Orsted Onshore Ireland Midco Limited

15: MEMORANDUM RESPONSE TO SUBMISSIONS RECEIVED

CUMULATIVE EFFECTS

Proposed Oatfield Wind Farm Project, Co. Clare: ABP
Case No. ABP-318782-24

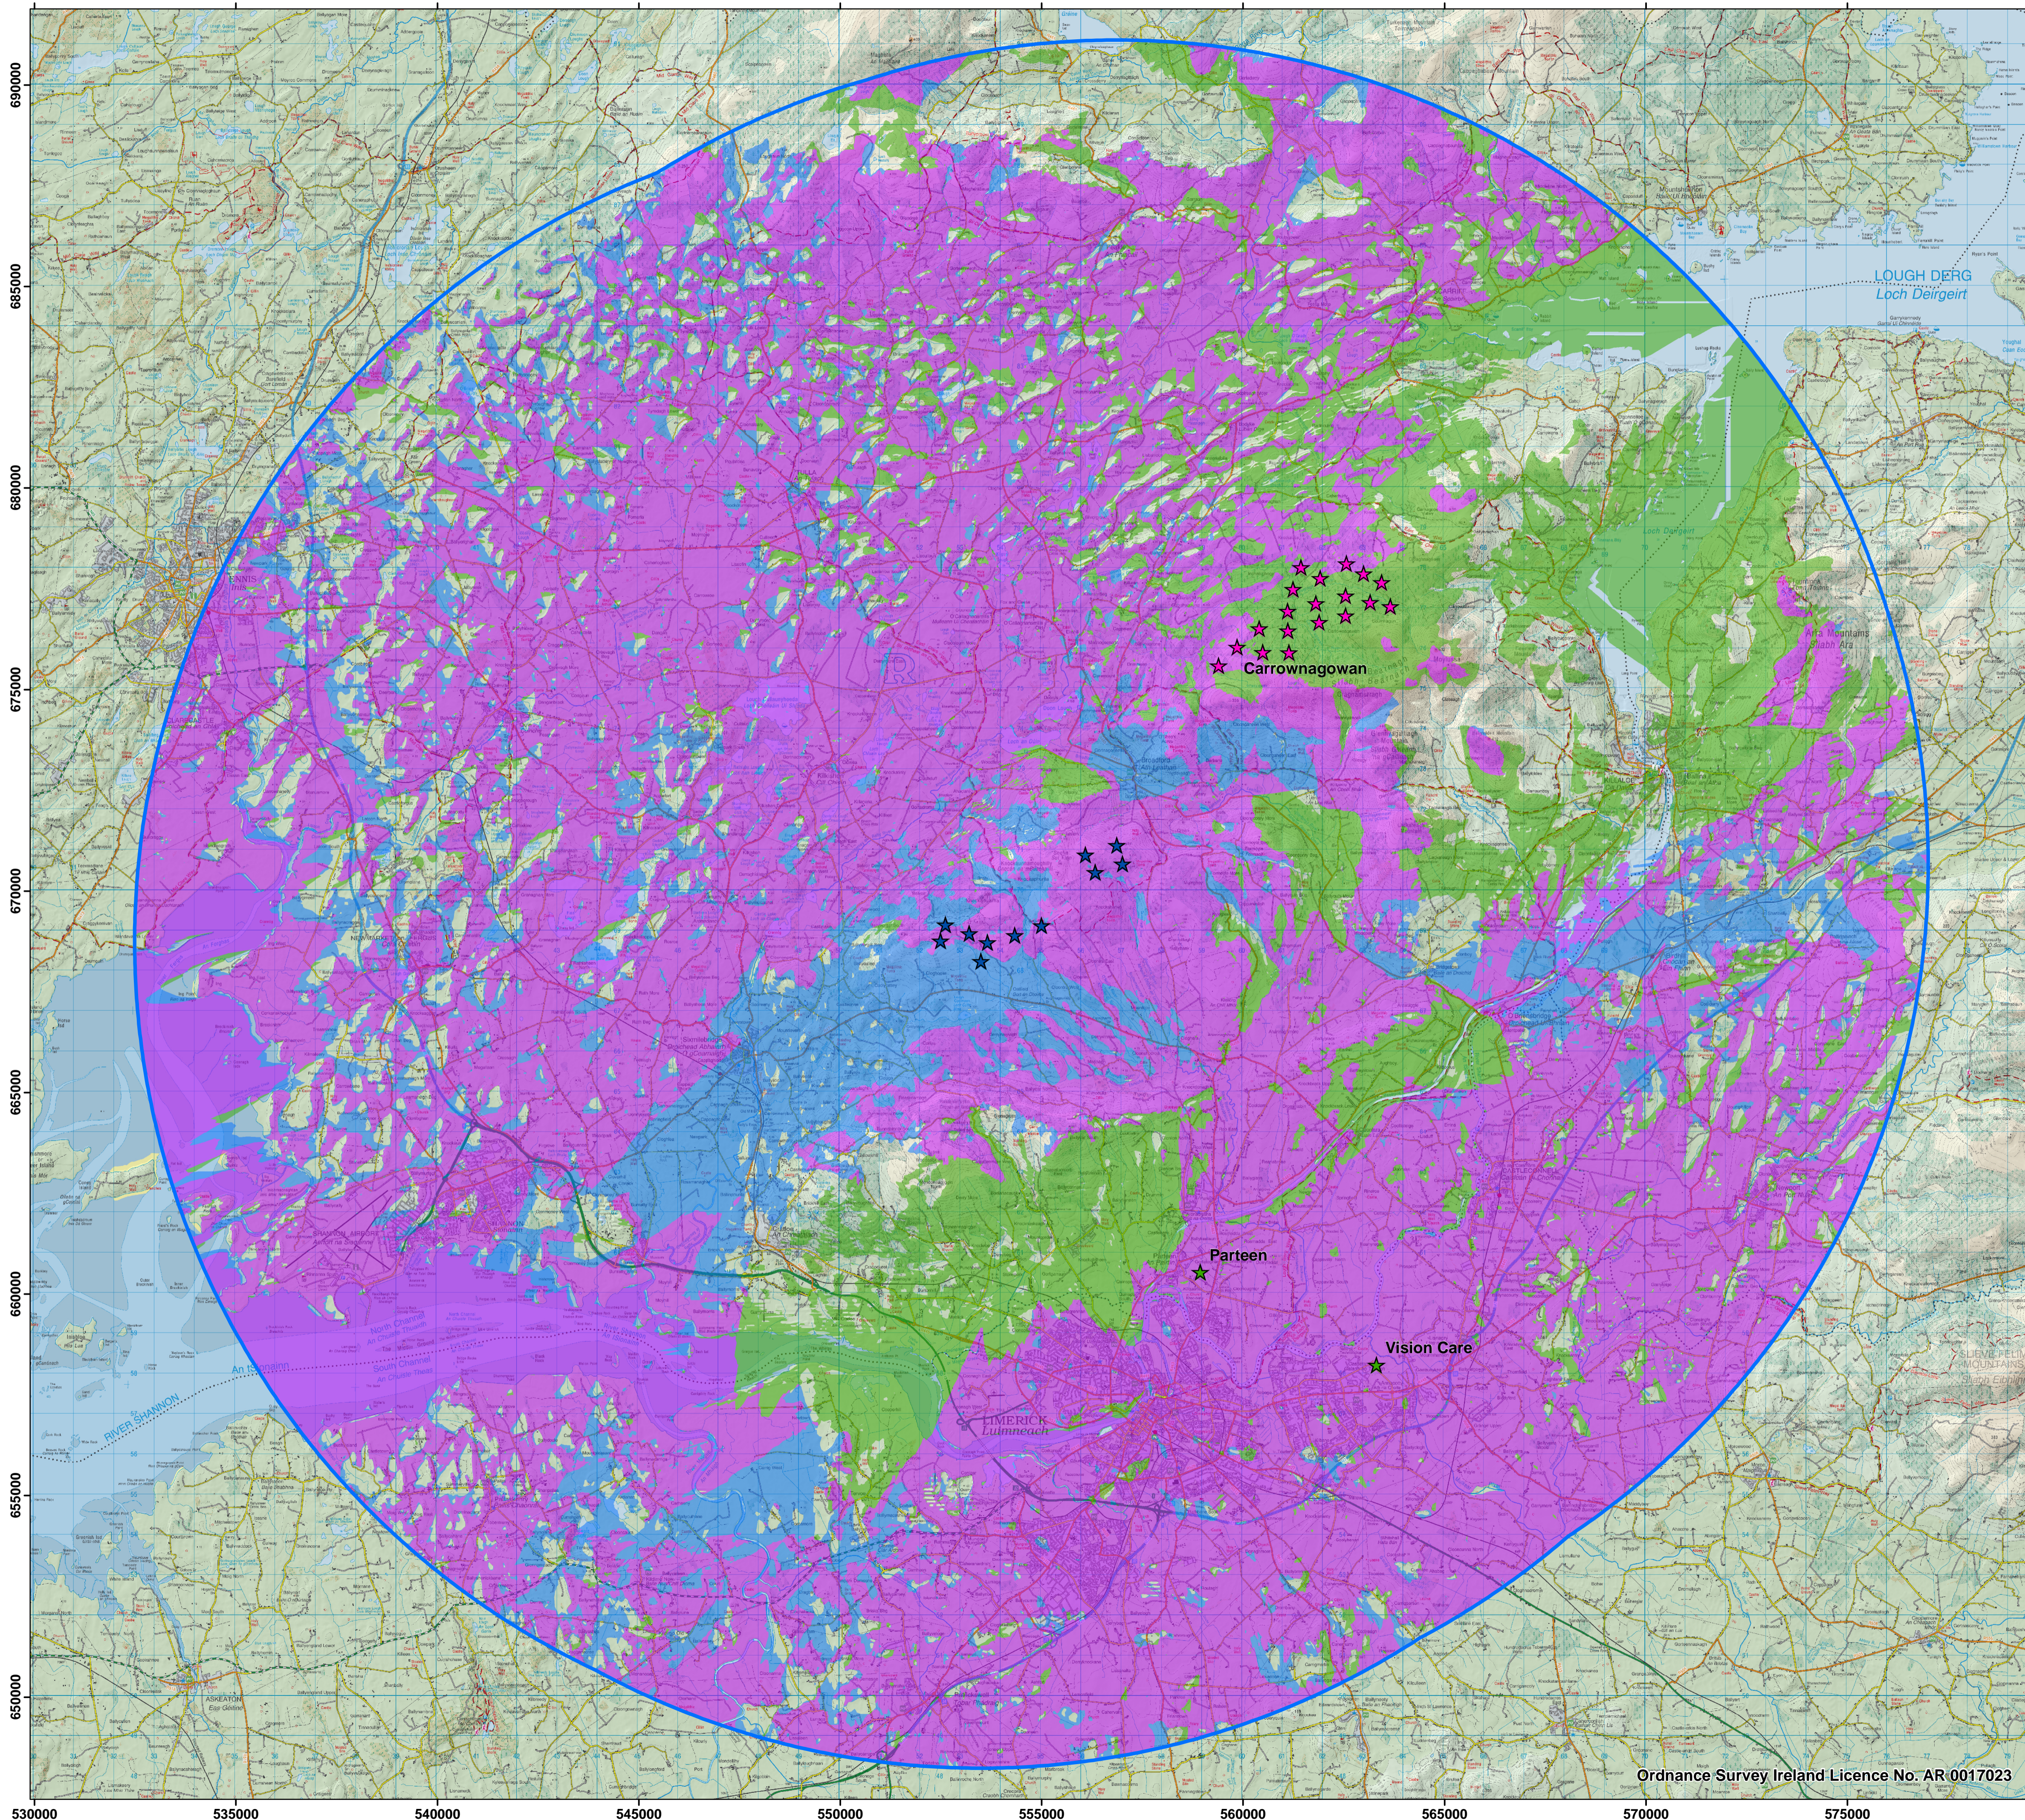
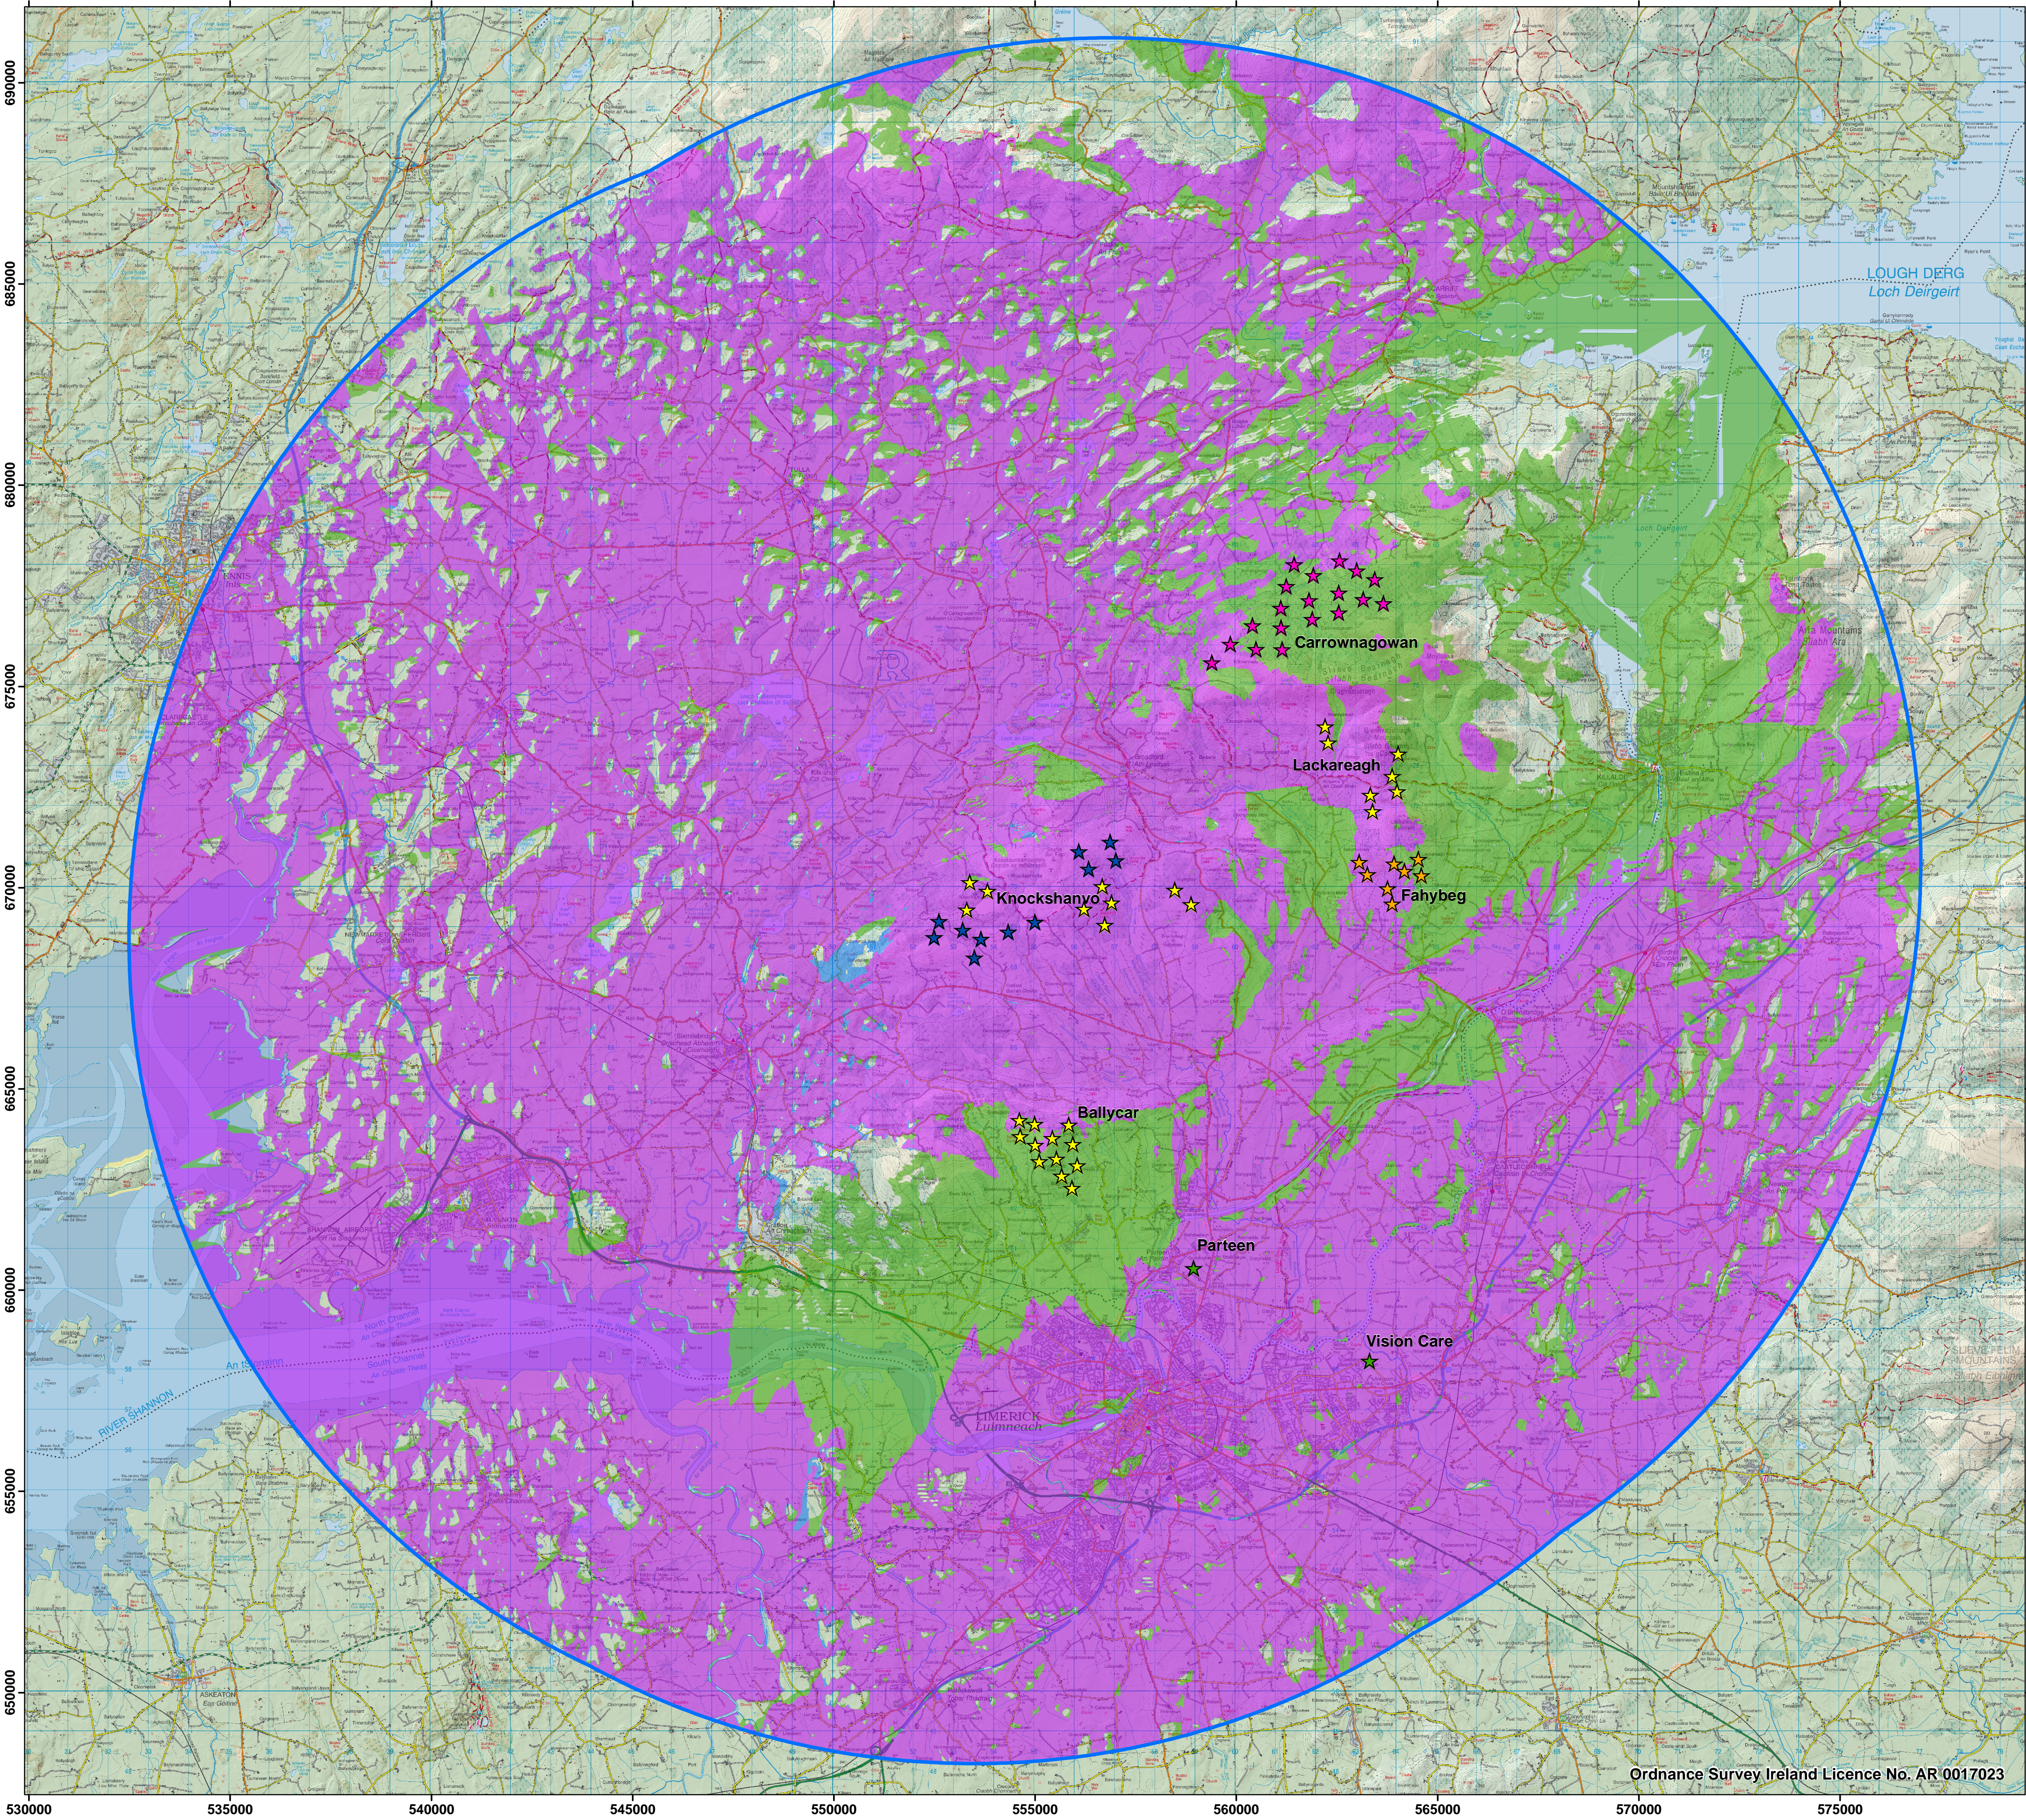
There were several concerns in the responses regarding the vast scale and cumulative effect of wind turbines in the East Clare area as a whole.

The potential cumulative effects on LVIA are discussed in **memorandum no. 10**. Also, Section 14.10 of **EIAR Chapter 14** assesses the potential cumulative impact of the Proposed Development and identifies 2 single turbine developments and 1 consented wind farm, 1 proposed wind farm (under appeal – subsequently permitted since the proposed Oatfield wind farm application was submitted), and 3 wind farms at pre-planning stage contained within the study area.

The cumulative assessment was divided into the 'Existing Baseline Scenario', which accounts for all existing and consented development within the study area, as per EIA Directive requirements and the 'Potential Future Cumulative Scenario', which accounts for all existing, consented, proposed and developments at the pre-planning stage.

With regard to the Knockshanvo development (in pre-planning), the proposed Oatfield Wind Farm and Knockshanvo Wind Farm will likely be perceived as one large wind energy development due to their locations being adjacent to one another. However, due to the dispersed layout, which presents as three distinct clusters, the overall scale and intensity of the combined developments are somewhat diminished. Indeed, the broad plateaux of hills and ridges within the Broadford Hills can well accommodate the combined developments without undue scale conflict. Nevertheless, the combination of both Proposed Developments will result in wind farm development becoming one of the more characteristic built features in this elevated landscape context. Whilst the combined views of the Oatfield and Knockshanvo turbines will generate some notable visual effects within the central study area and in the immediate surrounds of the turbines, the contained nature of the central study area, especially the lands directly south of the site, will often partially screen views of both the proposed Oatfield and Knockshanvo turbines. In fact, once existing intervening screening is accounted for, aside from the summit of the underlying hills and ridges, there will be very limited locations within the central study area, where clear views of all the turbines in both developments will be visible from a near distance.

Overall, and as per **EIAR Chapter 14**, it is considered that there will be a notable sense of wind farm proliferation within the central study area and in the wider eastern half of the study area. Wind farm development will become one of the more prominent built developments within the surrounding landscape, albeit these effects are slightly diminished as a result of the siting of the Knockshanvo development immediately adjacent to the Proposed Development. This results in the combined development being perceived as one larger consolidated array of turbines. Furthermore, due to the similar scale of the turbines in both developments, they will not generate any notable negative effects relating to scale conflict or and strong sense of visual tension between the two turbine arrays.

In conclusion, should all of the Proposed Developments within the study area be permitted and constructed, it is considered that the Oatfield Proposed Development will contribute to a cumulative effect in the order of High-medium in the potential future baseline scenario. It is not considered that the Proposed Development will generate significant cumulative landscape and visual effects.
